REQUEST

Current Zoning: O-2 PED (office, pedestrian overlay)
Proposed Zoning: MUDD-O PED (mixed use development, optional, Pedestrian Overlay)

The petition proposes to allow for the redevelopment of a parcel utilized as surface parking with multi-family residential and commercial uses. Golden Triangle #7 – Commonwealth, LLC, Levine Properties, Inc. Levine Properties, Inc. Brittany Lins and Collin Brown, Alexander Ricks, PLLC Meeting is required and has been held. Report available online. Number of people attending the Community Meeting: 26

Staff does not recommend approval of this petition in its current form.

**RZ-1**

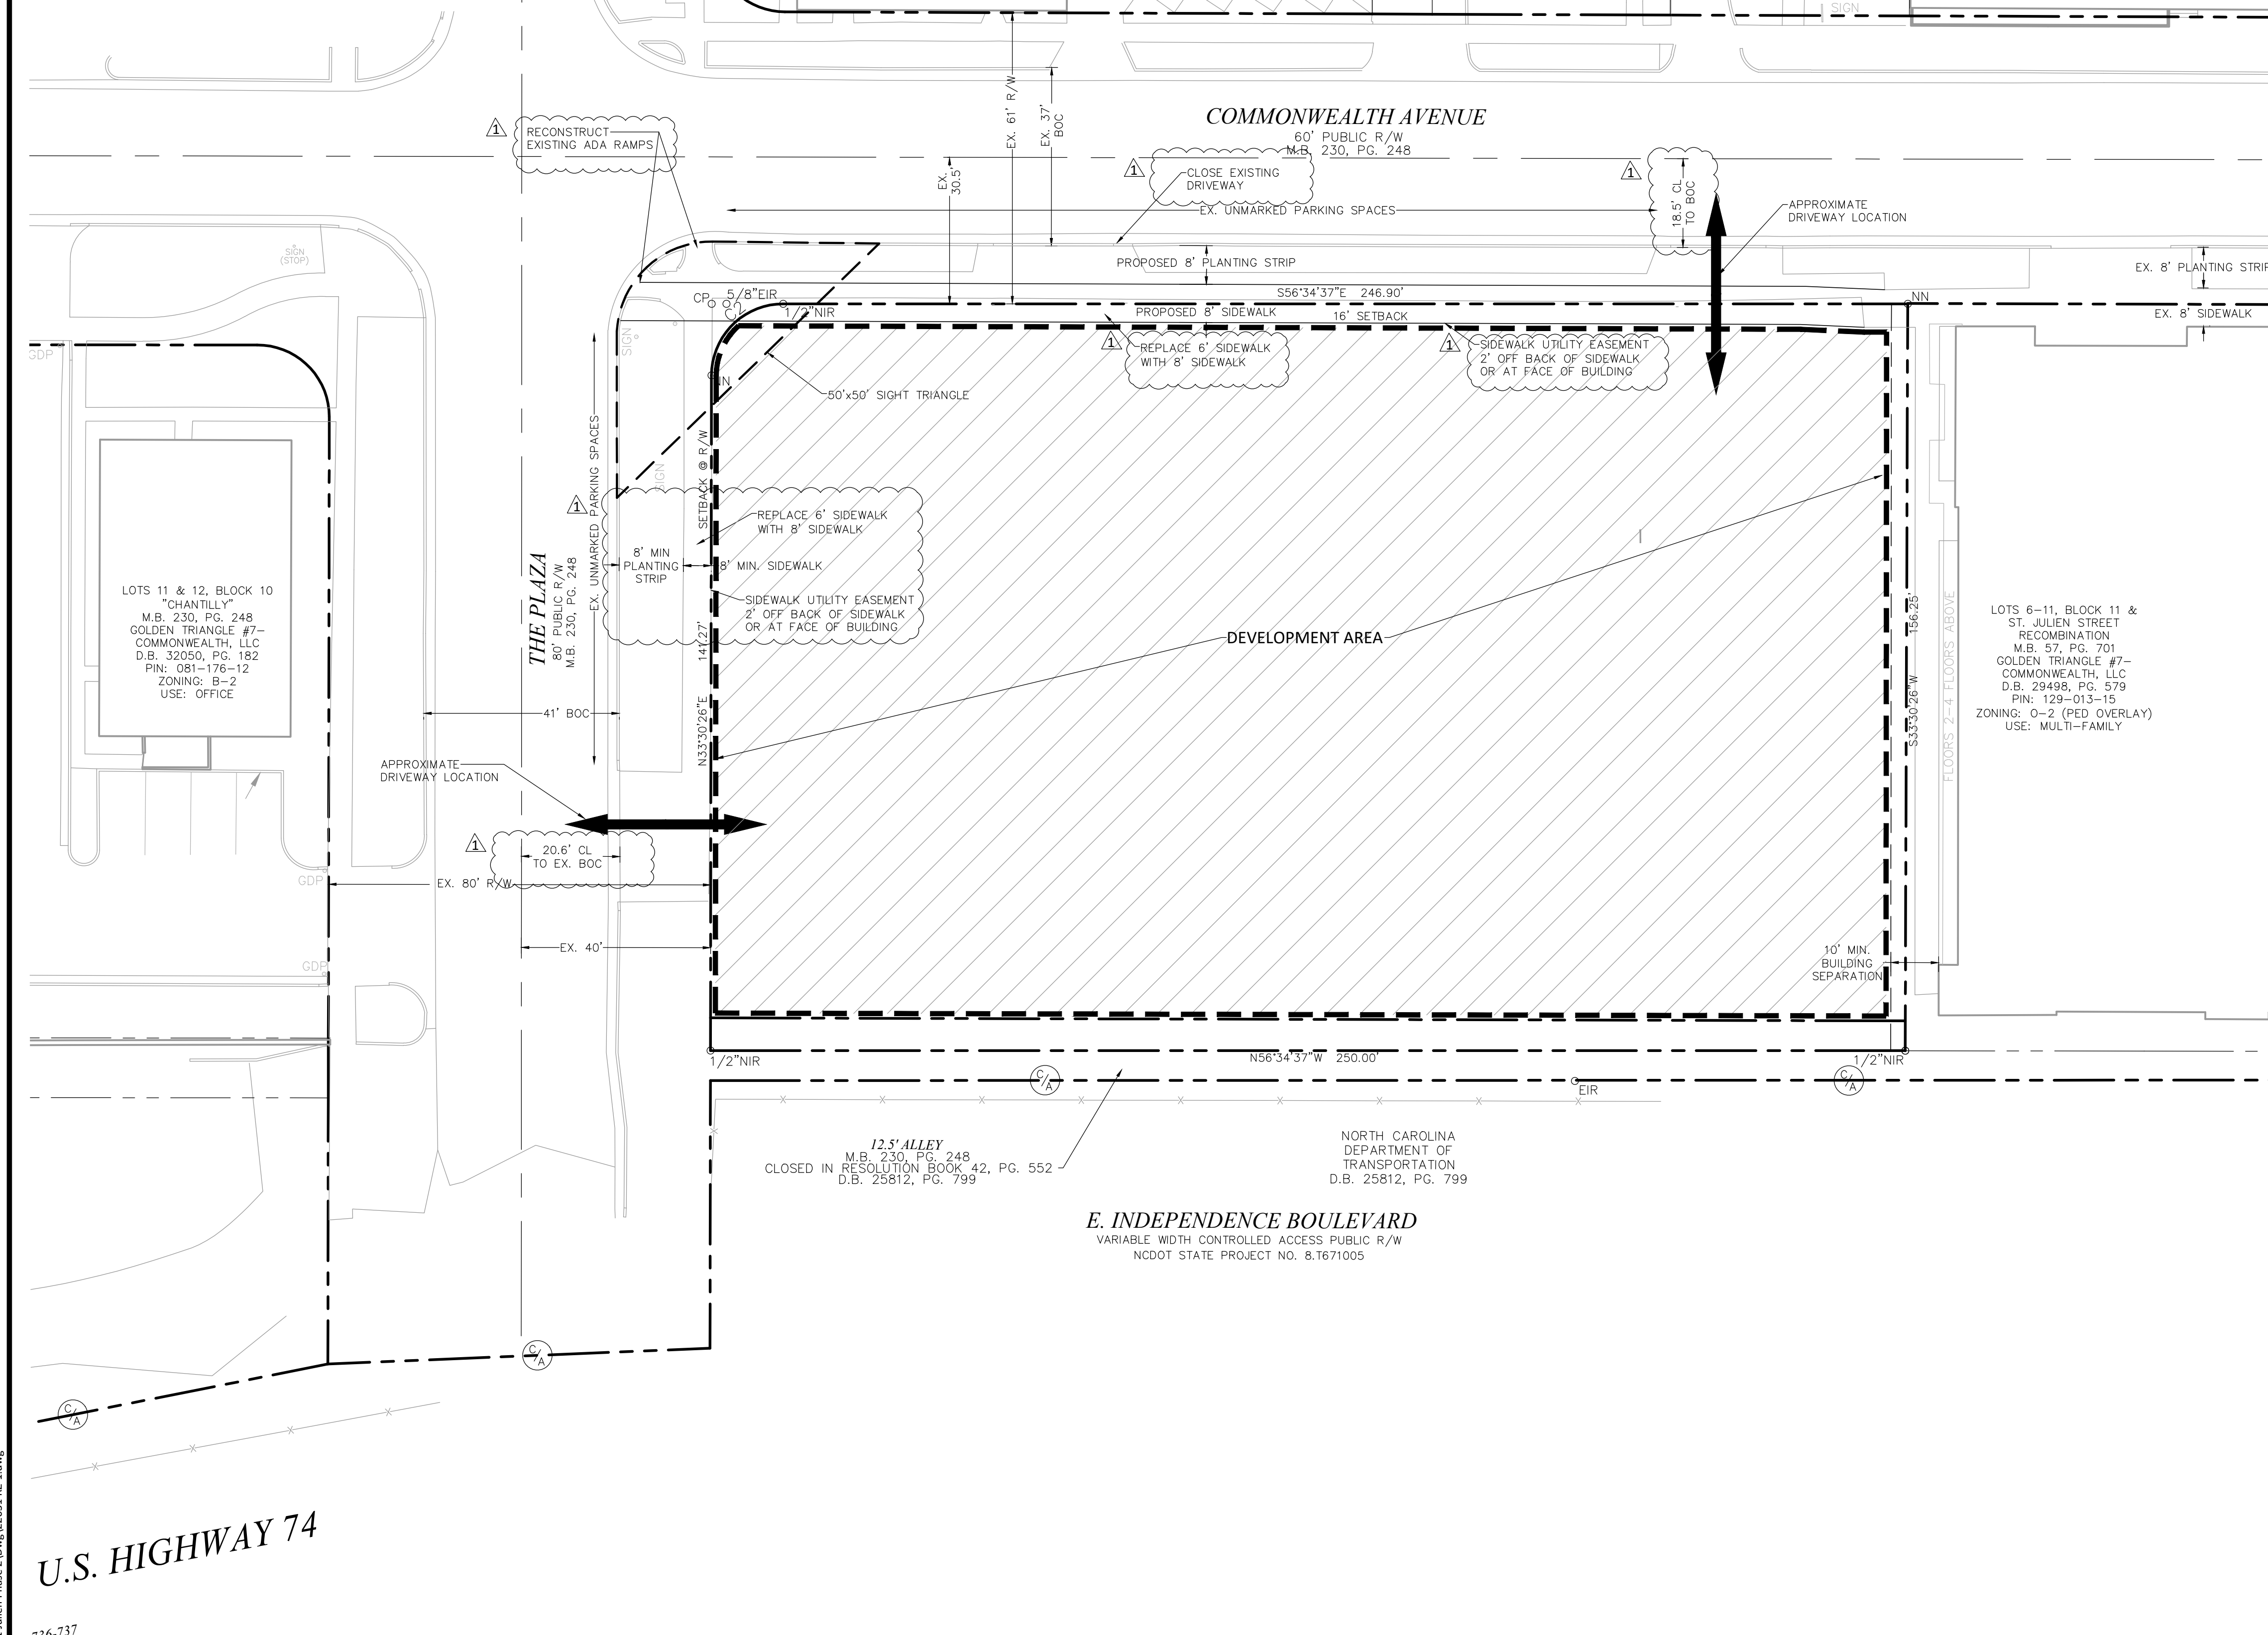
1. Show required right-of-way trees.

2. Comprehensive Transportation Review (CTR): The Comprehensive Transportation Review was recently approved by City Council under the new UDO. In lieu of a TTM for the proposed site CDOT has requested the petitioner complete a CTR for the site. The petition's zoning falls within the medium to high intensity development which based on the 1,775 daily trips will trigger Tier 3 (14 mitigation points) for multimodal assessment and Tier 3 (6 mitigation points) for transportation demand management assessment. The petitioner shall review and assess the publicly accessible pedestrian network within ¼ mile walking distance of the site to identify multimodal infrastructure to meet the Tier 3 (14 mitigation points) for multimodal assessment. Petitioner shall also provide transportation demand management strategies to meet Tier 3 (6 mitigation points) to reduce vehicle trips and encourage alternative modes of transportation.

3. Reduce the maximum height to provide contextual sensitivity to the surrounding building forms.
4. Revise note 7 under the Design Guidelines to commit to community benefits to achieve building height above 80'. Commit to specific community benefits.
5. Identify building envelopes(s) rather than one development area.
6. Remove optional provision allowing for a drive-through.
